STATE OF NORTH CAROLINA
DEPARTMENT OF TRANSPORTATION

January 23, 2015

Subject: **Modification Request for the Individual Section 404 and Section 10 Permits, Section 401 Water Quality Certification and CAMA Major Development Permit** for the Wilmington Bypass from north of US 74/76 in Brunswick County to US 421 in New Hanover County. Federal Aid Project Nos. NHF-0017 (96) and STM-0017 (97), Division 3, TIP No. R-2633B. Debit \$475 from WBS Element 34491.1.2

PROJECT REFERENCE NO. R-2633B	SHEET NO. 37
RW SHEET NO.	
ROADWAY DESIGN ENGINEER	HYDRAULICS ENGINEER
<b>PRELIMINARY PLANS</b> DO NOT USE FOR CONSTRUCTION <b>PERMIT DRAWING</b> <b>SHEET 62 OF 73</b> <b>REVISED 2/4/2015</b>

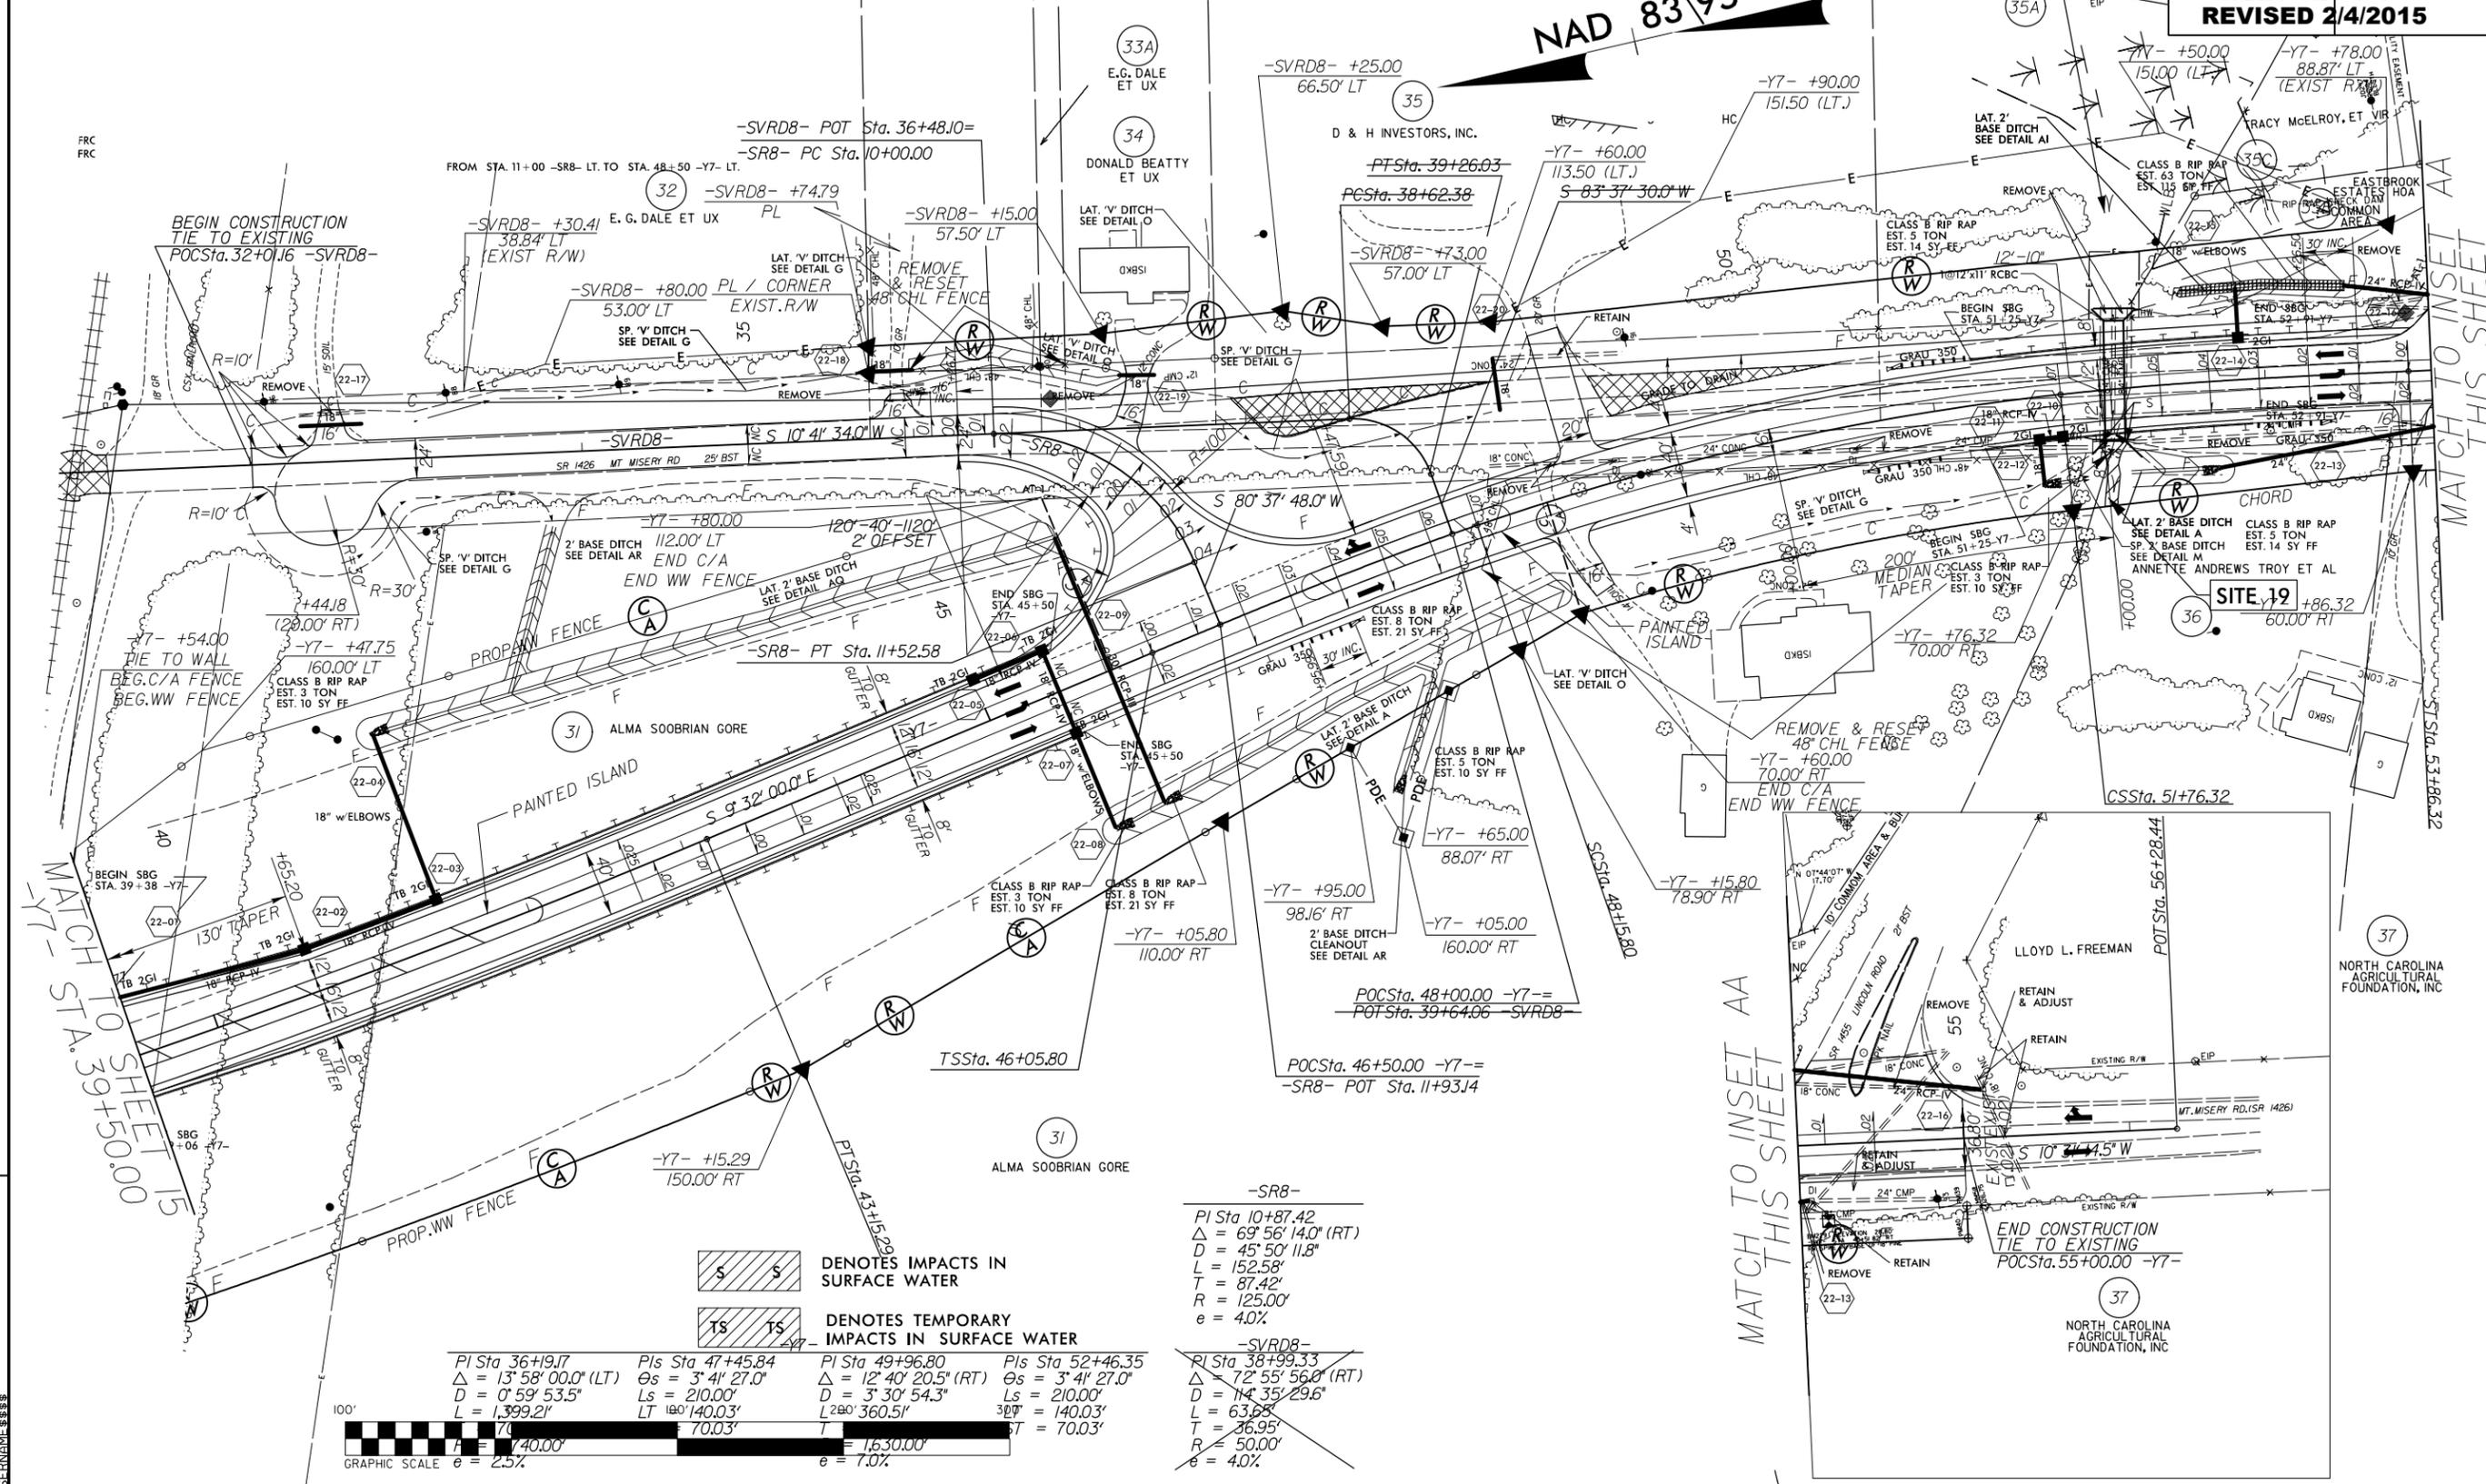
Site 19, detour drawing, Sheet 2L was revised from the original drawing. The original profile on this drawing showed the temporary pipes buried 3 feet. This was later questioned and the consultant collected more recent data. The drawing was changed but the temporary pipes on the profile now appear to be sitting on top of the streambed. See enclosed screen snapshot drawing showing the pipes will be buried one foot. Permit Drawing Sheets 64 and 65 of 73 have been revised and included in this application. No changes have been made to jurisdictional impacts.
